# GRADING AND EROSION CONTROL PLANS FOR WALDEN SANITATION DISTRICT WASTEWATER TREATMENT PLANT PROJECT EL PASO COUNTY, COLORADO MARCH 2026

PCD PROJ. NO. : PPR2538

OVERALL SITE PLAN  
1"=60'

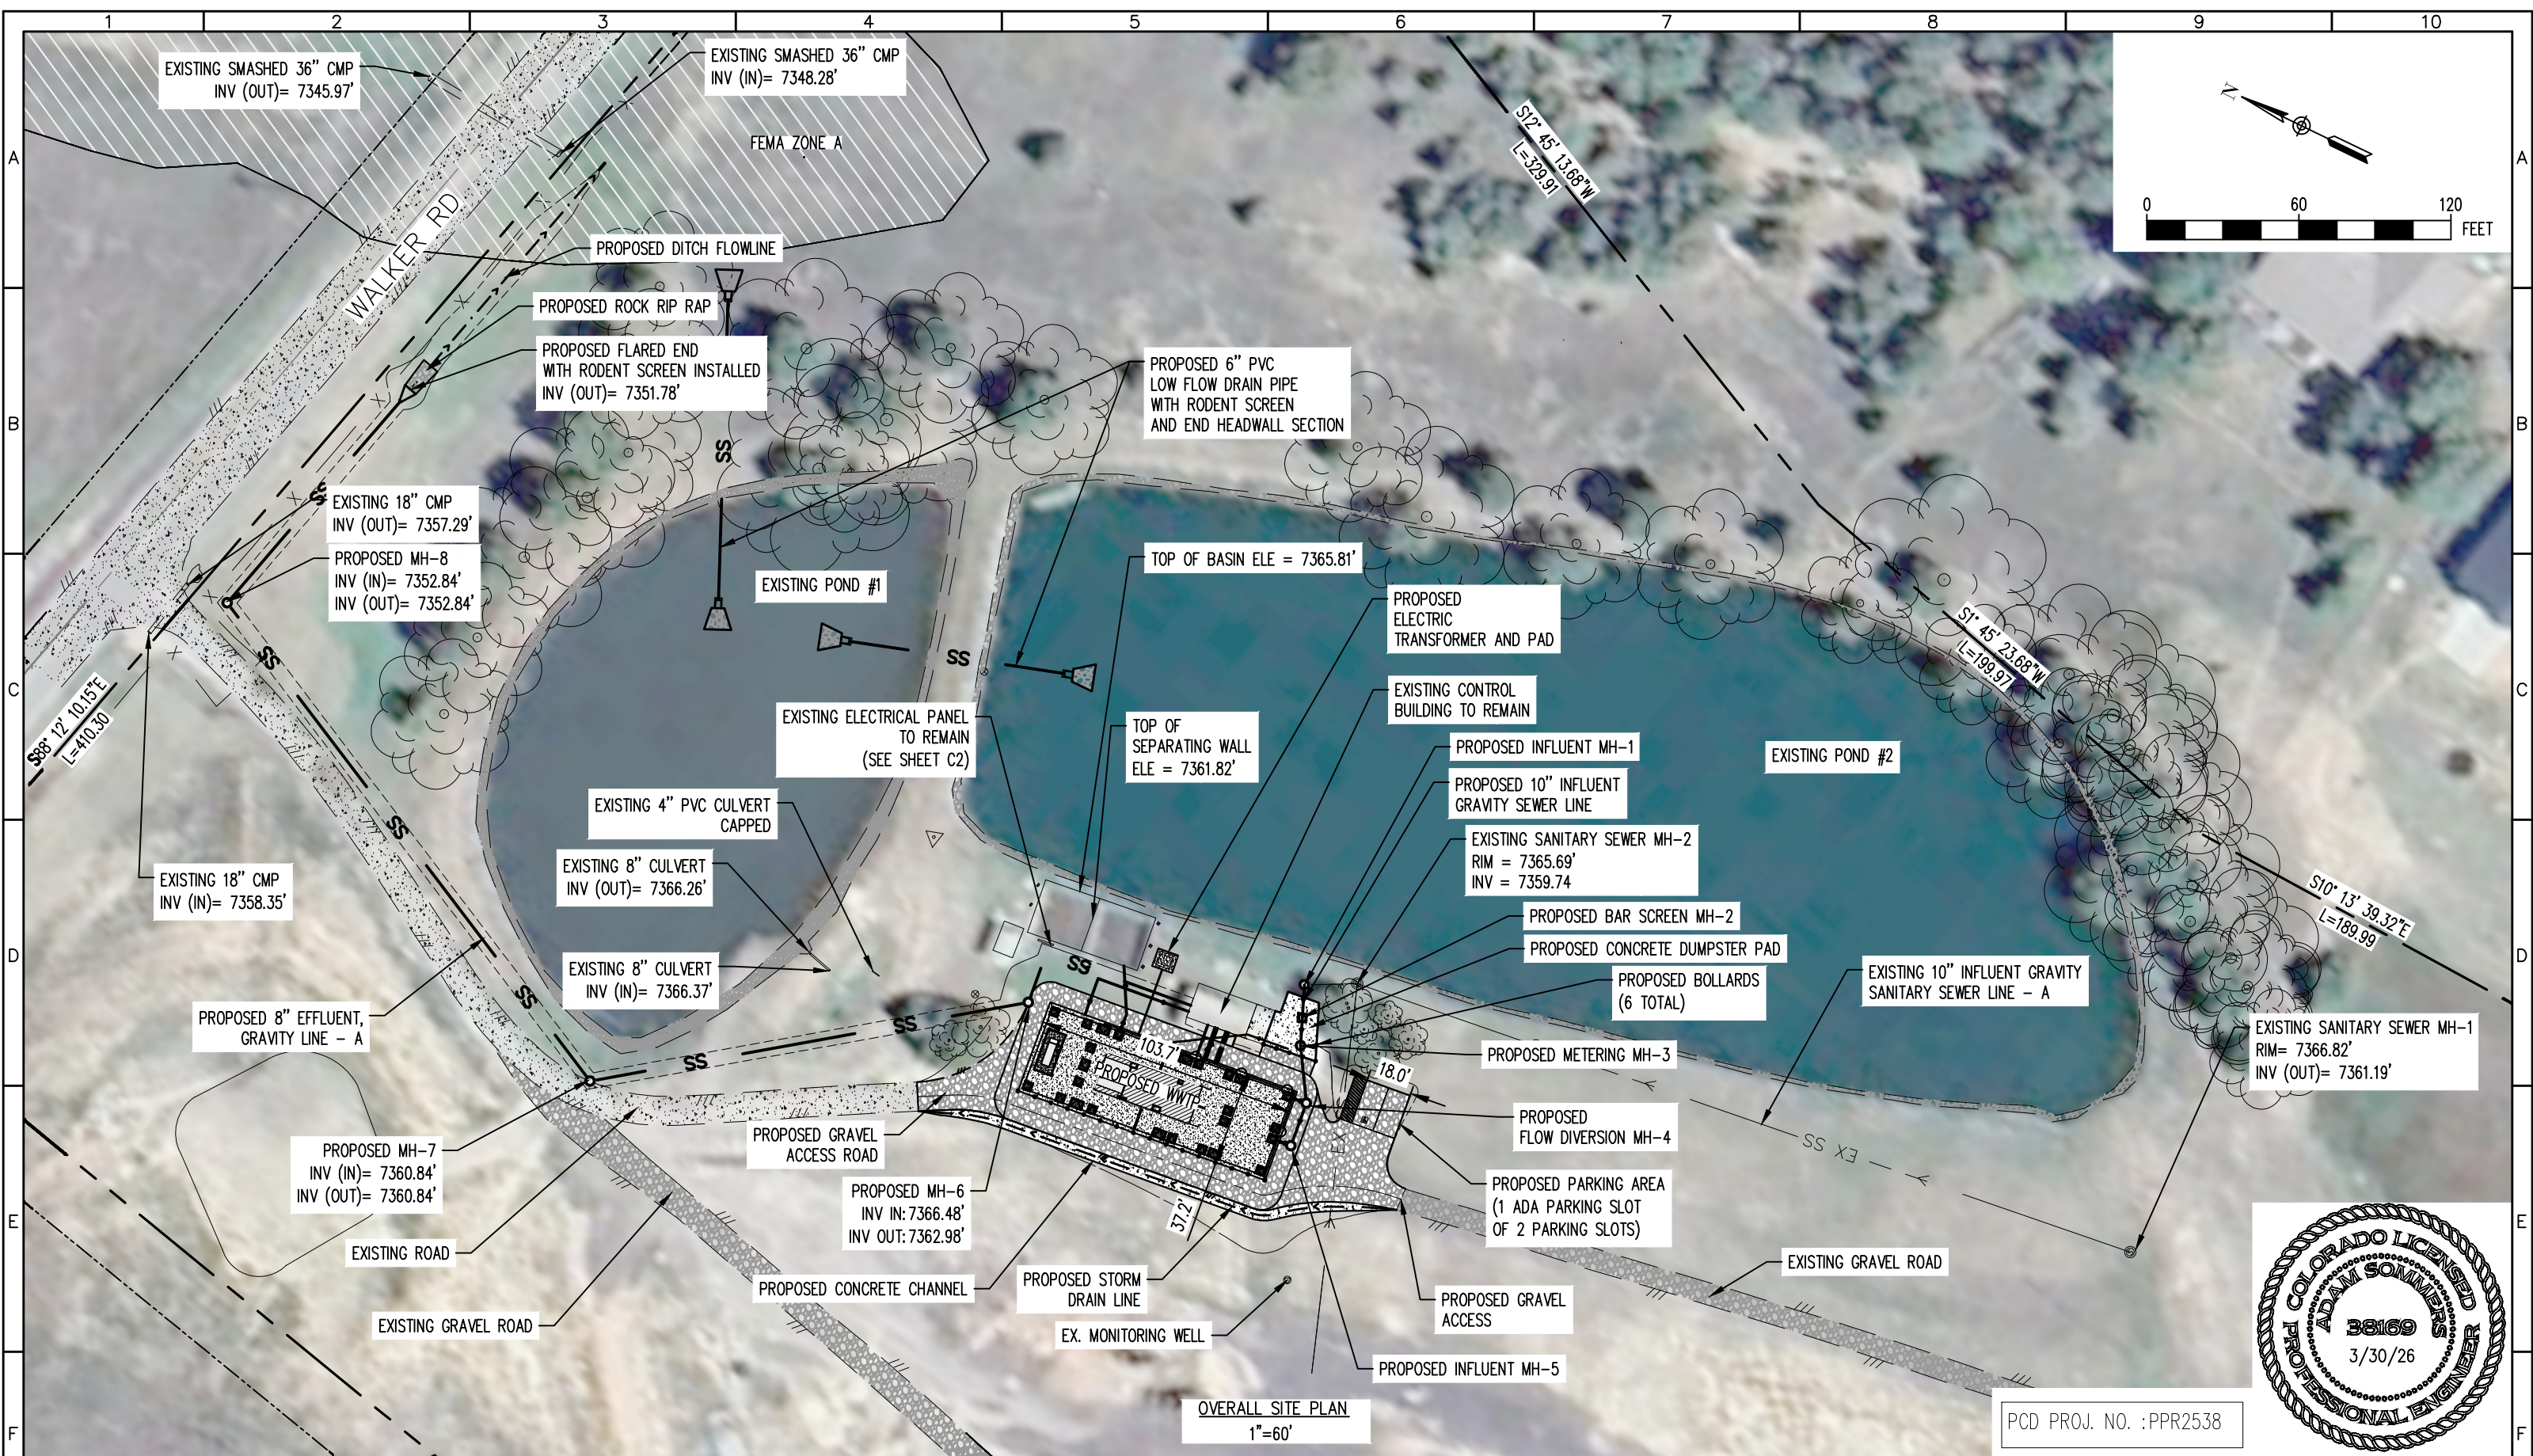
EPC DPW Stormwater did not fully review the last GEC submission since it was not associated with a stormwater permit. New information provided with this submission has triggered the requirement for an ESQCP, so full comments will be provided at this time. See comment on sheet 12 for additional information.

If "limits of disturbance" and "construction boundary" are the same, change to "limits of construction/disturbance" or otherwise show as separate line types for each on the legend and figure.
